**Byers Gill Solar  
EN010139**

# 3.3 DCO Schedule of Changes

Deadline 2 – August 2024

Drawing Title  
**Street Works, Public Rights of Way & Access Plans**  
Sheet 3 of 13  
**APFP Regulation 5(2)(k)**

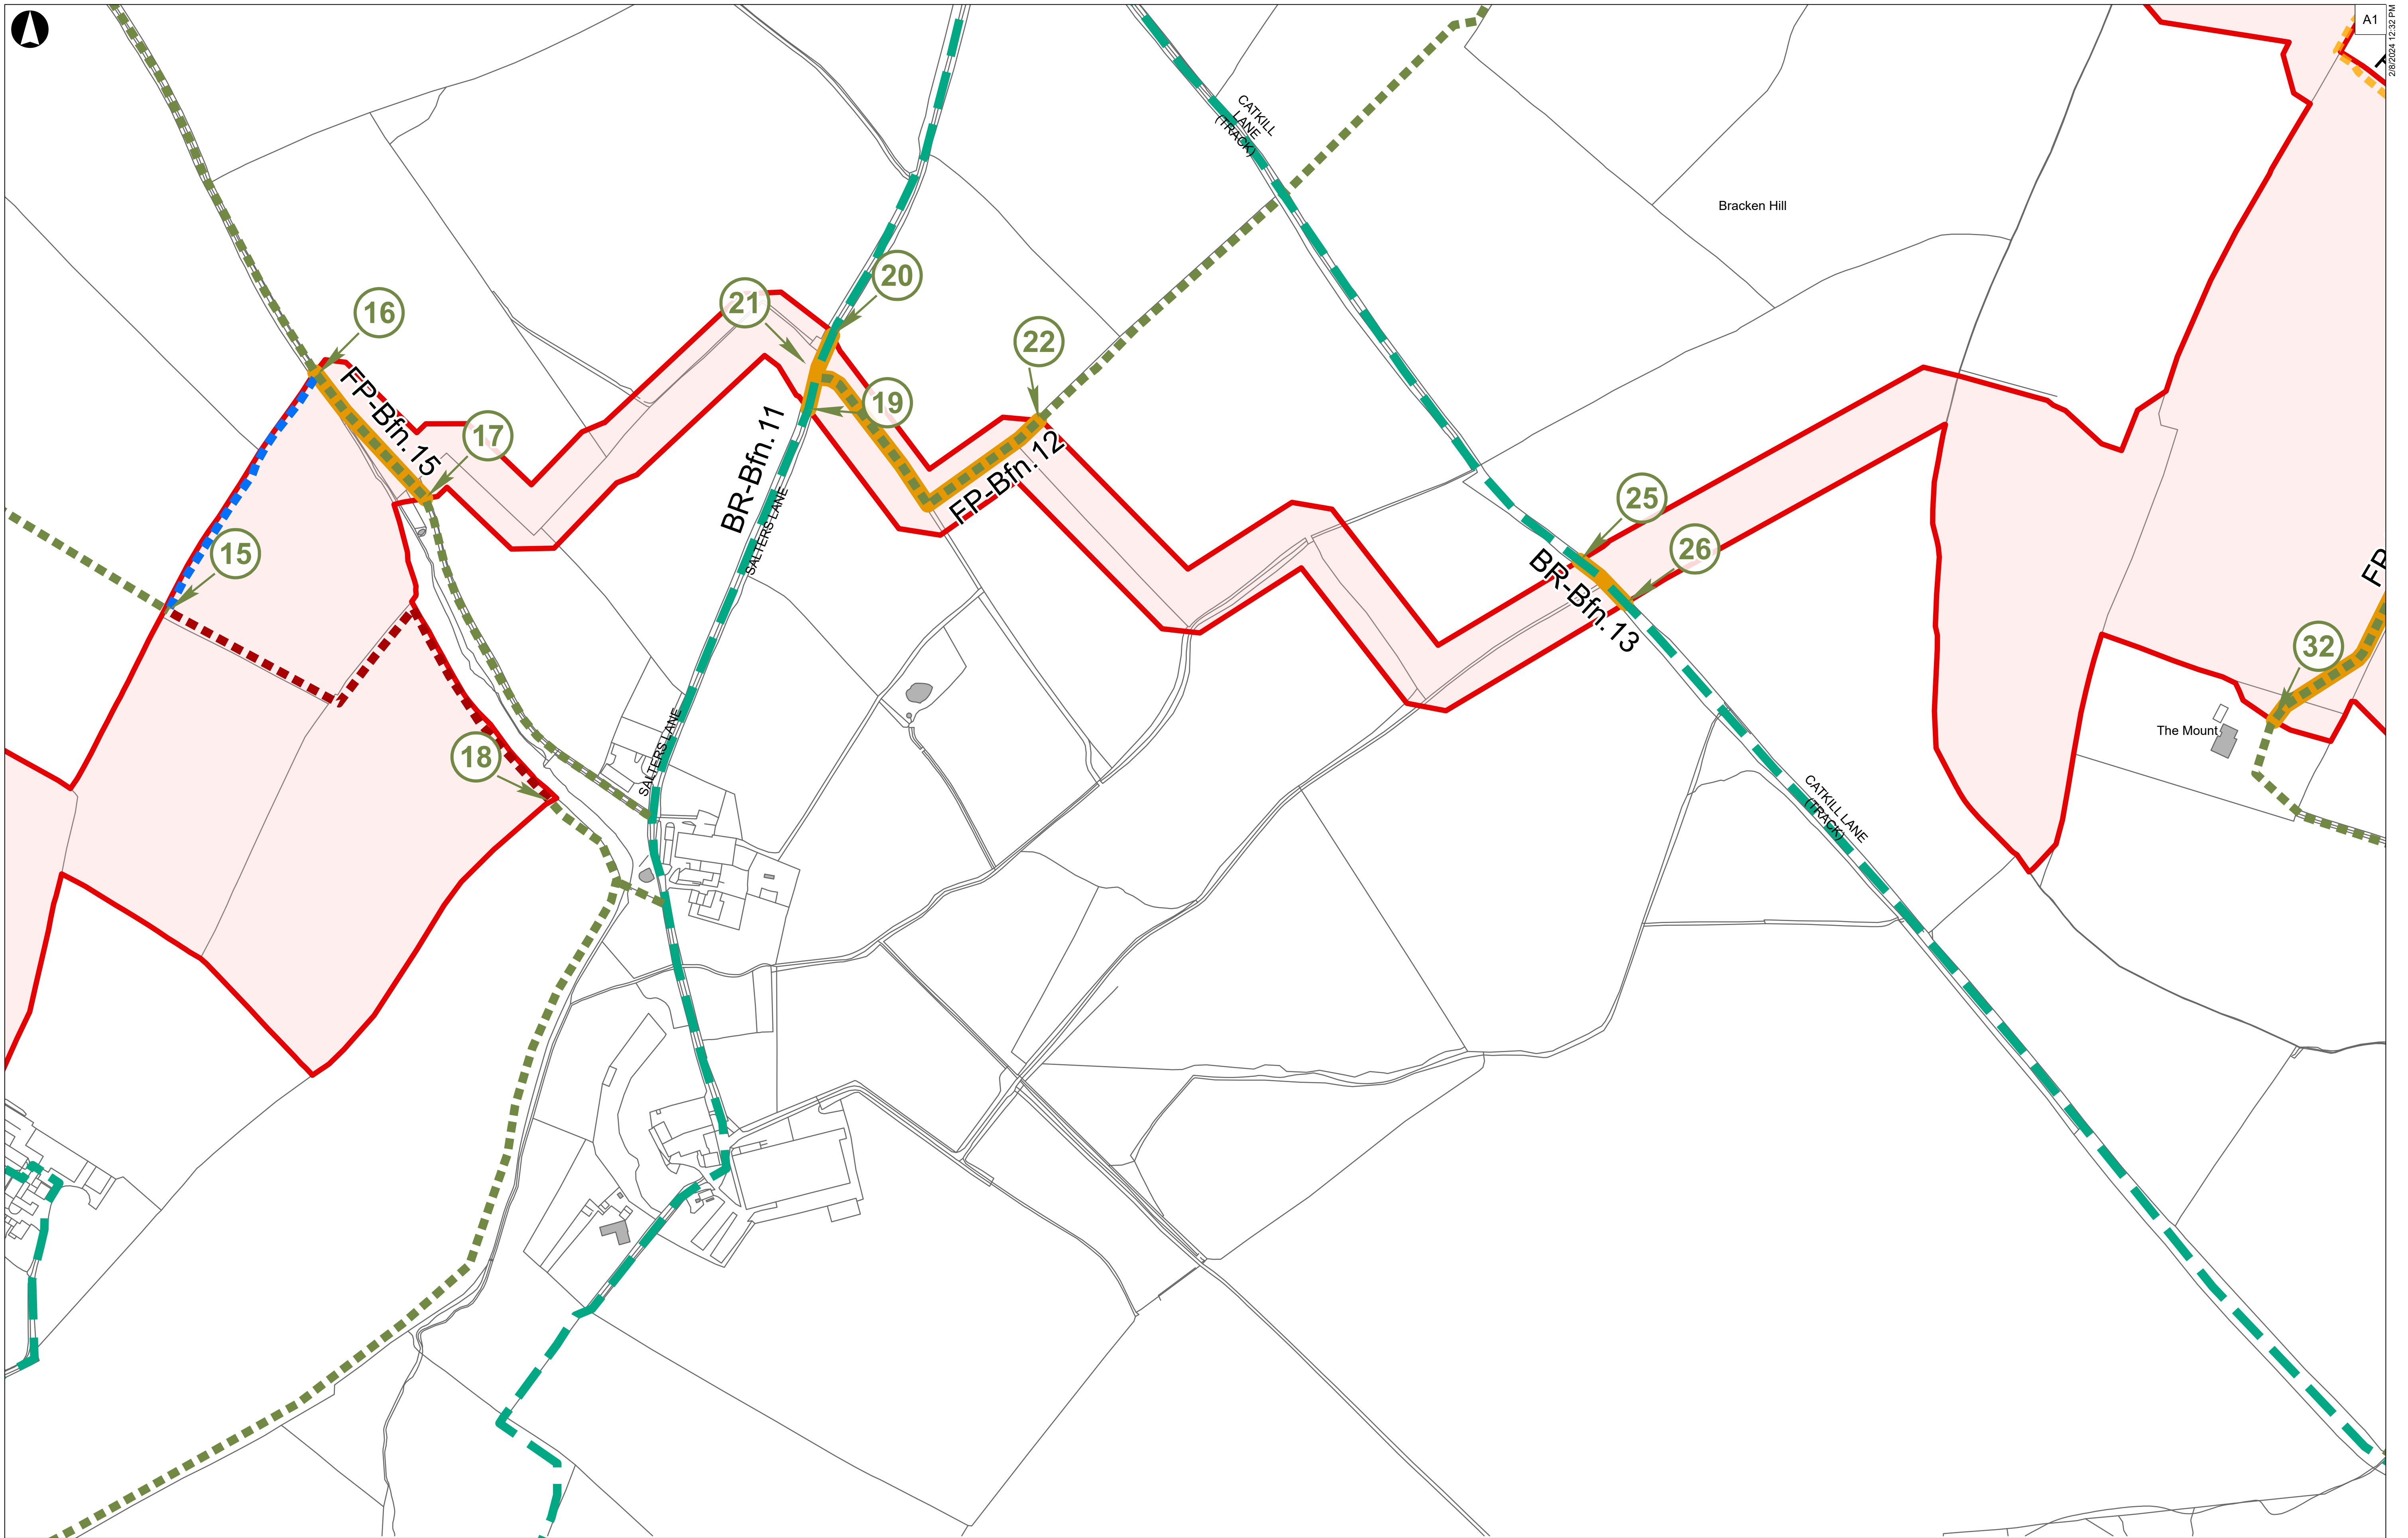
For example, row 2 of the table has been amended as follows:

<i>Parish of Brafferton</i>	<i>Unnamed Road</i>	<i>Cable works beneath the width of <del>highway</del> <u>street</u> comprising a length of 320m as shown between points marked A and B on sheet 3 of the street works, public rights of way and access plans.</i>
---------------------------------	-------------------------	--------------------------------------------------------------------------------------------------------------------------------------------------------------------------------------------------------------------

Sheet 9 of 13

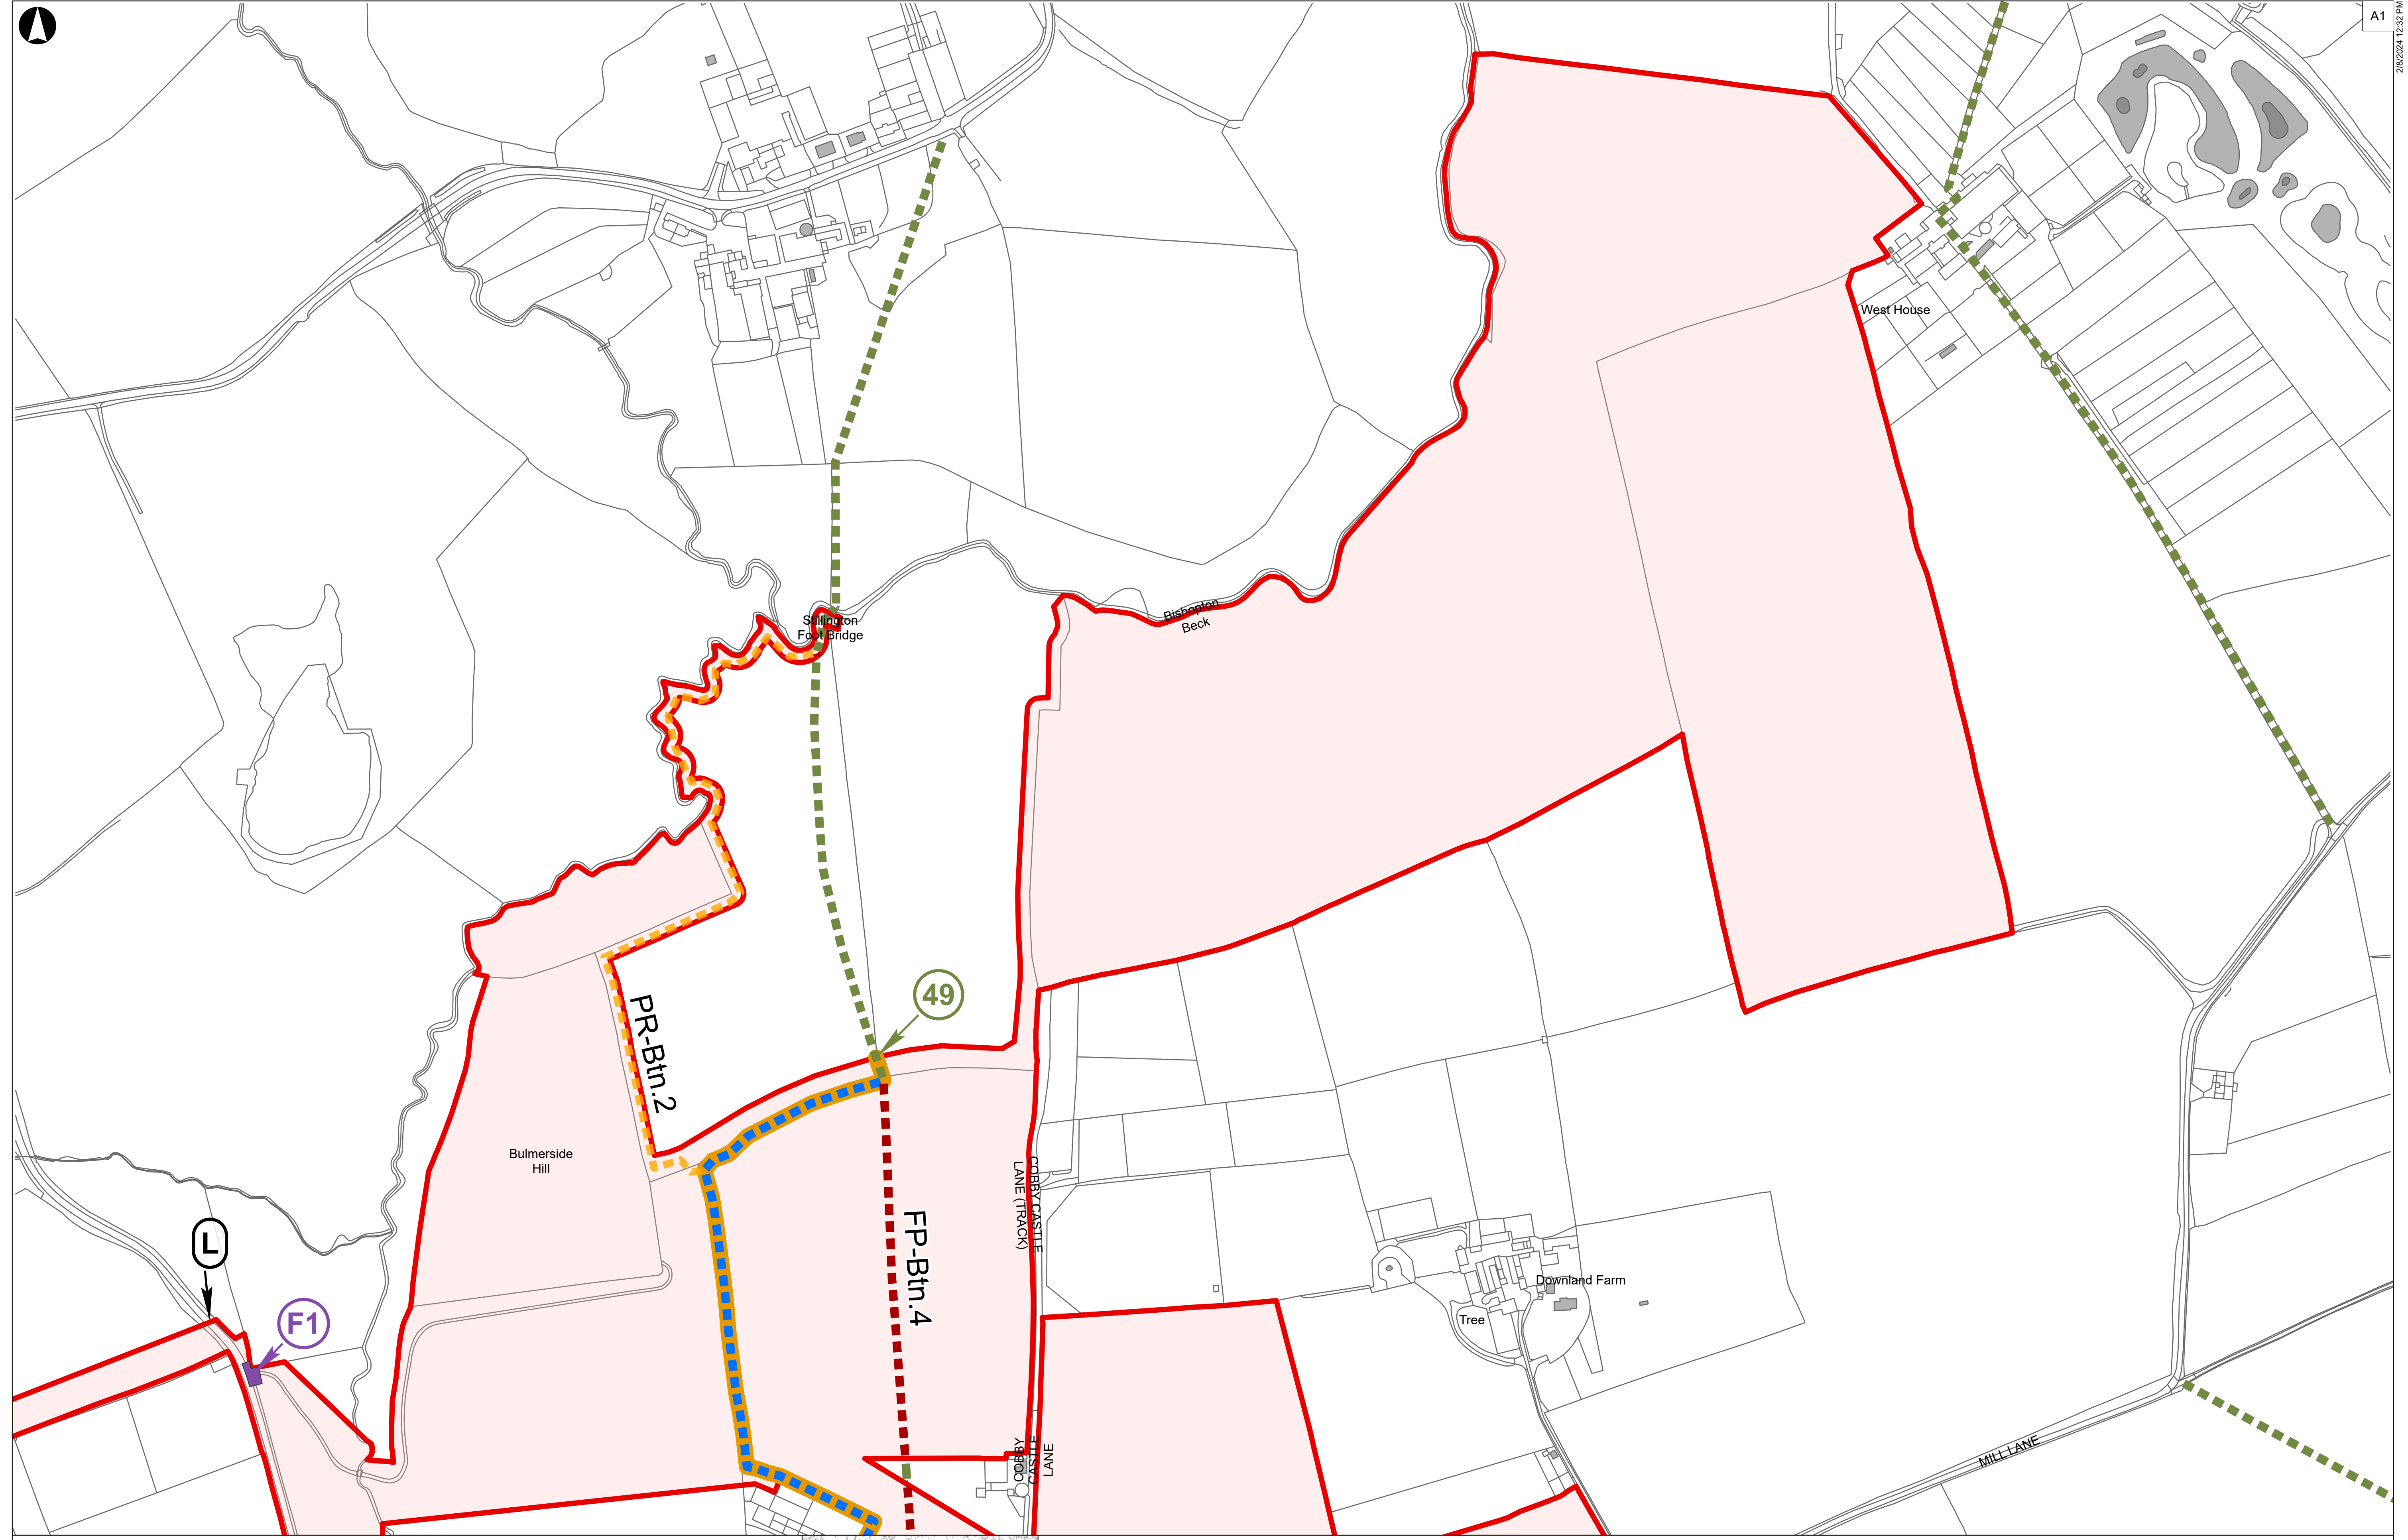
<u><i>Parish of Bishopton</i></u>	<u><i>Folly Bank</i></u>	<u><i>Cable works beneath the width of street as shown with reference CC5 on sheet 9 of the street works, public rights of way and access plans.</i></u>
<u><i>Parish of Redmarshall</i></u>	<u><i>Redmarshall Road, in the vicinity of Morington Bridge</i></u>	<u><i>Cable works beneath the width of street as shown with reference CC6 on sheet 11 of the street works, public rights of way and access plans.</i></u>

These two rows have been added to provide street works descriptions for two locations where the Applicant proposes to carry out cabling works across the width of a street for the purpose of delivering the off-road cable route. These descriptions are included as a correction to Revision 1 of the dDCO.

<p>The following rows have been removed from the table of street works in Schedule 3:</p> <table border="1" data-bbox="577 373 1263 1029"> <tr> <td data-bbox="577 373 779 703"> <p><del>Parish of Bishopton</del></p> </td> <td data-bbox="779 373 891 703"> <p><del>The Green</del></p> </td> <td data-bbox="891 373 1263 703"> <p><del>Cable works beneath the width of highway comprising a length of 330m as shown between points marked K and M on sheets 9 and 11 of the street works, public rights of way and access plans.</del></p> </td> </tr> <tr> <td data-bbox="577 703 779 1029"> <p><del>Parish of Bishopton</del></p> </td> <td data-bbox="779 703 891 1029"> <p><del>High Street</del></p> </td> <td data-bbox="891 703 1263 1029"> <p><del>Cable works beneath the width of highway comprising a length of 700m as shown between points marked M and N on sheets 9 and 11 of the street works, public rights of way and access plans.</del></p> </td> </tr> </table>	<p><del>Parish of Bishopton</del></p>	<p><del>The Green</del></p>	<p><del>Cable works beneath the width of highway comprising a length of 330m as shown between points marked K and M on sheets 9 and 11 of the street works, public rights of way and access plans.</del></p>	<p><del>Parish of Bishopton</del></p>	<p><del>High Street</del></p>	<p><del>Cable works beneath the width of highway comprising a length of 700m as shown between points marked M and N on sheets 9 and 11 of the street works, public rights of way and access plans.</del></p>	<p>These two rows were previously included to provide street works descriptions for the cabling works proposed to be carried out for the on-road cable route through Bishopton.</p> <p>These two have been removed because the cable route optionality in this location has been resolved in favour of the off-road route to the south of Bishopton Village and the Order limits have been updated to remove the on-road cable route through Bishopton. See the Applicant’s Notification of Intention to Submit New or Revised Information – Accepted at the discretion of the Examining Authority [AS-010] for further details.</p>
<p><del>Parish of Bishopton</del></p>	<p><del>The Green</del></p>	<p><del>Cable works beneath the width of highway comprising a length of 330m as shown between points marked K and M on sheets 9 and 11 of the street works, public rights of way and access plans.</del></p>						
<p><del>Parish of Bishopton</del></p>	<p><del>High Street</del></p>	<p><del>Cable works beneath the width of highway comprising a length of 700m as shown between points marked M and N on sheets 9 and 11 of the street works, public rights of way and access plans.</del></p>						
<p><b>Schedule 11, Part 4 (For the Protection of the Environment Agency)</b></p>	<p>Part 4 (For the Protection of the Environment Agency) has been removed from Schedule 11.</p>	<p>Following engagement with the Environment Agency, Part 4 of Schedule 11 has been removed as a responsive amendment to the removal of Article 7(1)(b) above. The parties agree that the Protective Provisions previously included at Part 4 of Schedule 11 are redundant.</p>

Corresponding amendments have been made to the Street Works, Public Rights of Way and Access Plans to indicate these locations.
